Our Ref: EP/46/20/HH
Your Ref:

Town & Country Planning Act 1990 (as amended)
Town & Country Planning (Development Management Procedure) (England) Order 2015
Application for Planning Permission for Works or Extension to a Dwelling

Development Demolish existing conservatory to rear elevation. Enlarge existing dining room extension to create a new garden room.
Location Dorestan 10 Worthing Road East Preston

Block Plan shows area bounded by: 506515.96, 102755.92 506605.96, 102845.92 (at a scale of 1:500), OSGridRef: TQ 656 280. The representation of a road, track or path is no evidence of a right of way. The representation of features as lines is no evidence of a property boundary.

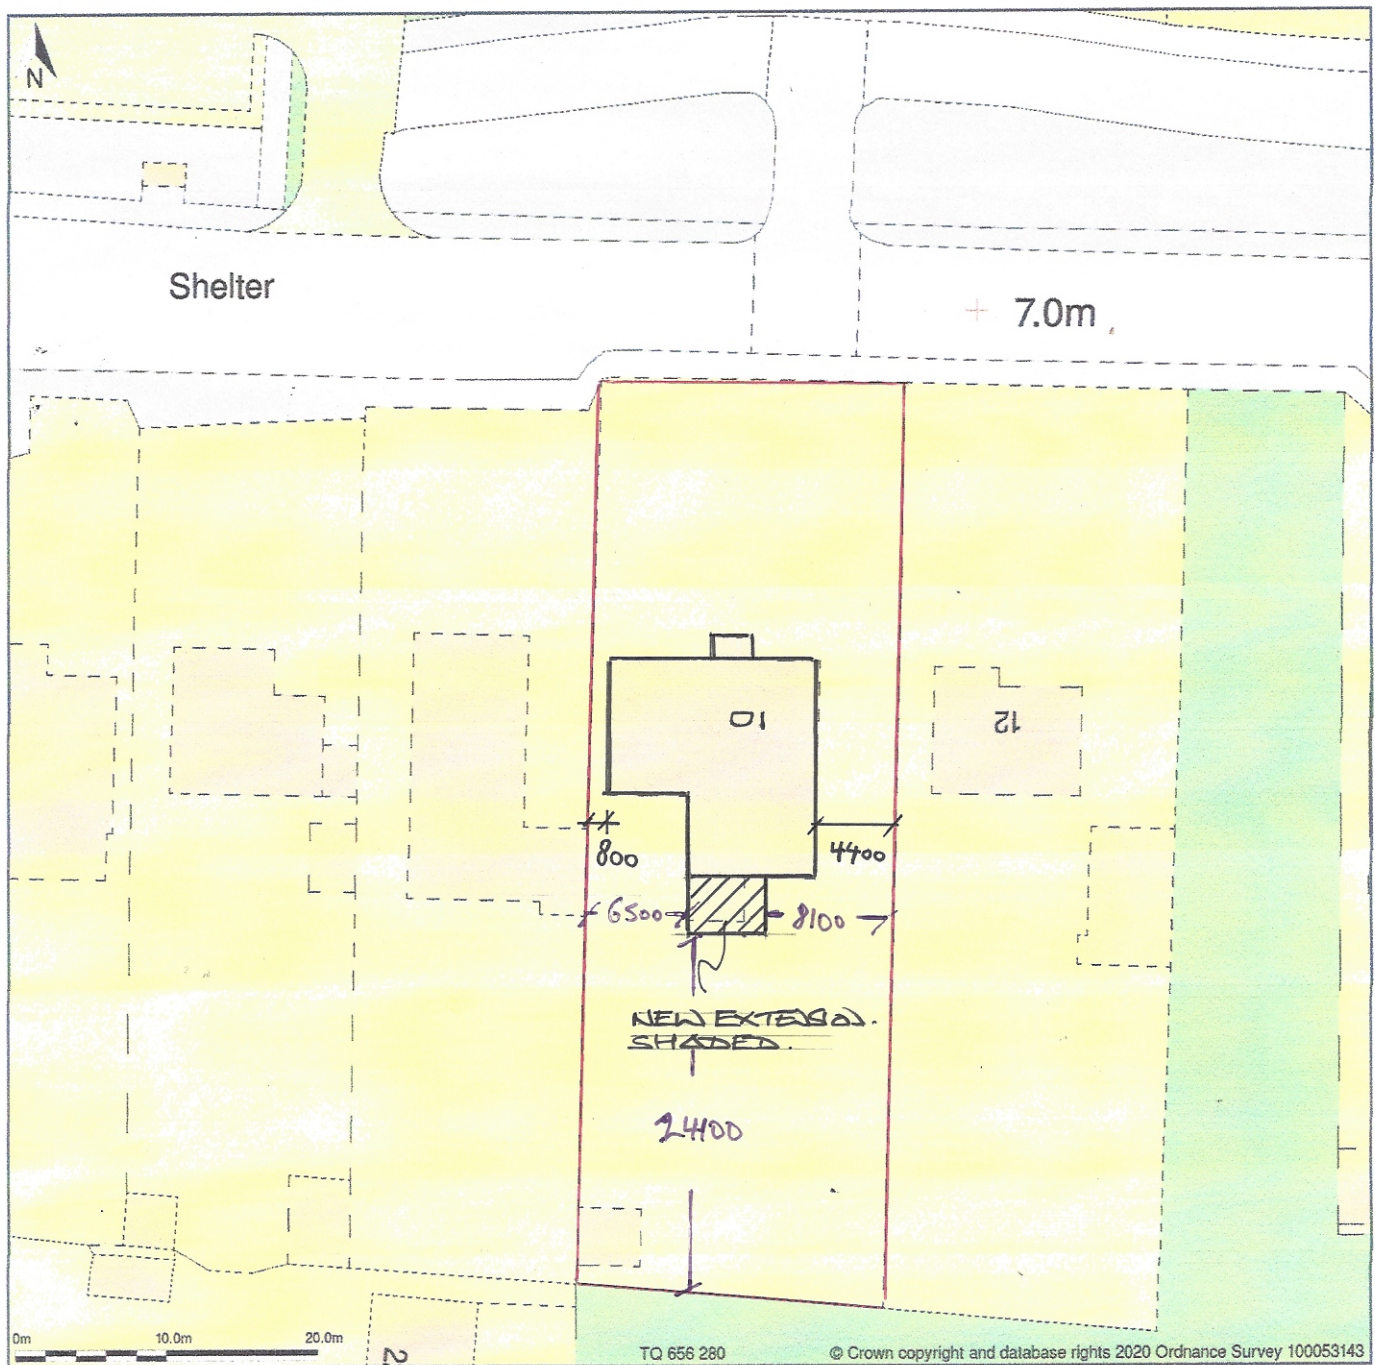
Dimensions: You are required to include dimensions on the block from the proposed extension to all site boundaries.

Proposed Block: The proposed block appears to be showing a new porch. Please clarify and amend the plan.
